To: [REDACTED]
Subject: FW: ALDINGBOURNE GOSPEL HALL - APPLIC REF. AL/38/18/PL - LANDSCAPE CONDITION DISCHARGE (COND. 4)

Ok so I've had a look at the details here and can advise that yes an augmented (enhanced) to existing plan should suffice. The red line site overflow area whilst presently not showing additional landscaping, does sit in an established and well screened location, so I don't envisage we are looking for a huge landscaping scheme here.

Drawing No:
BOGNOR
BG.8.03.M

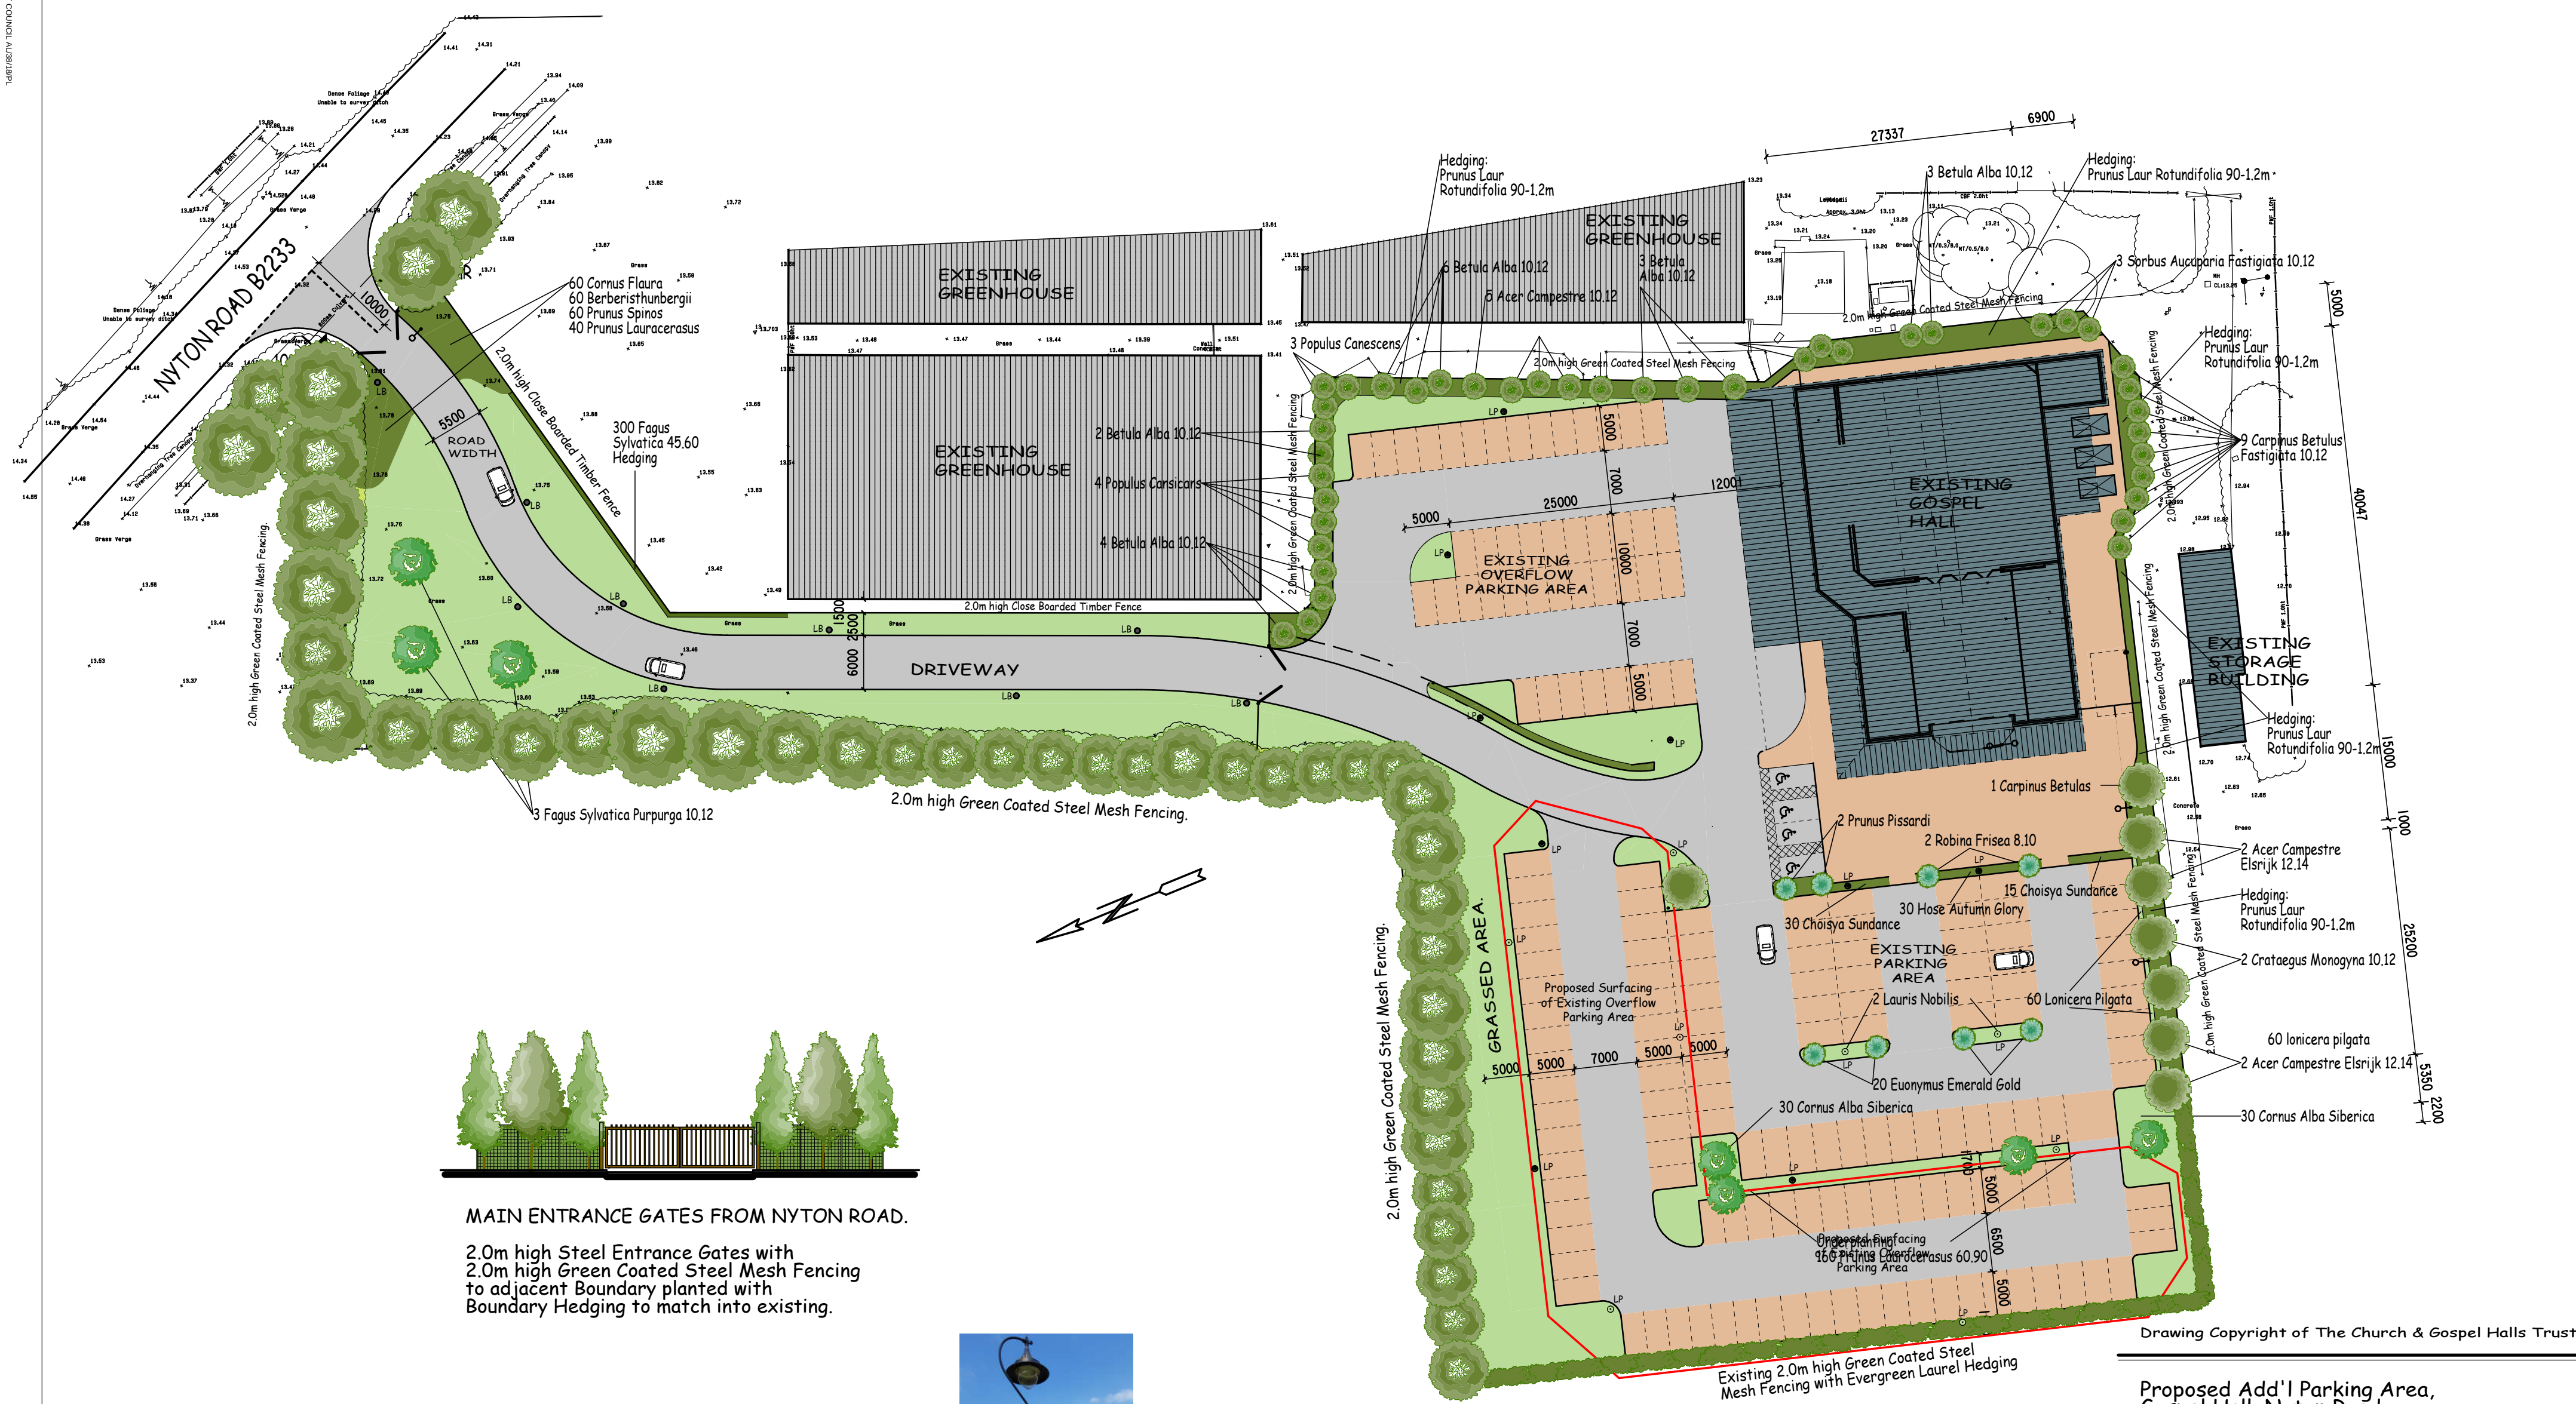
As the applicant has suggested if they can show the distinction between existing and proposed with emphasis on what is to be new with detail in plan form showing species choice, actual proposed plant quantities and size at time of planting.

A note re maintenance which confirms replacement regime in case of plant failure would be a 'good to see' also.

There would need to be a clearer distinction between existing and proposed planting and presumably details of ground preparation for planting and maintenance/management of the planted trees/shrubs. Would anything else be required?
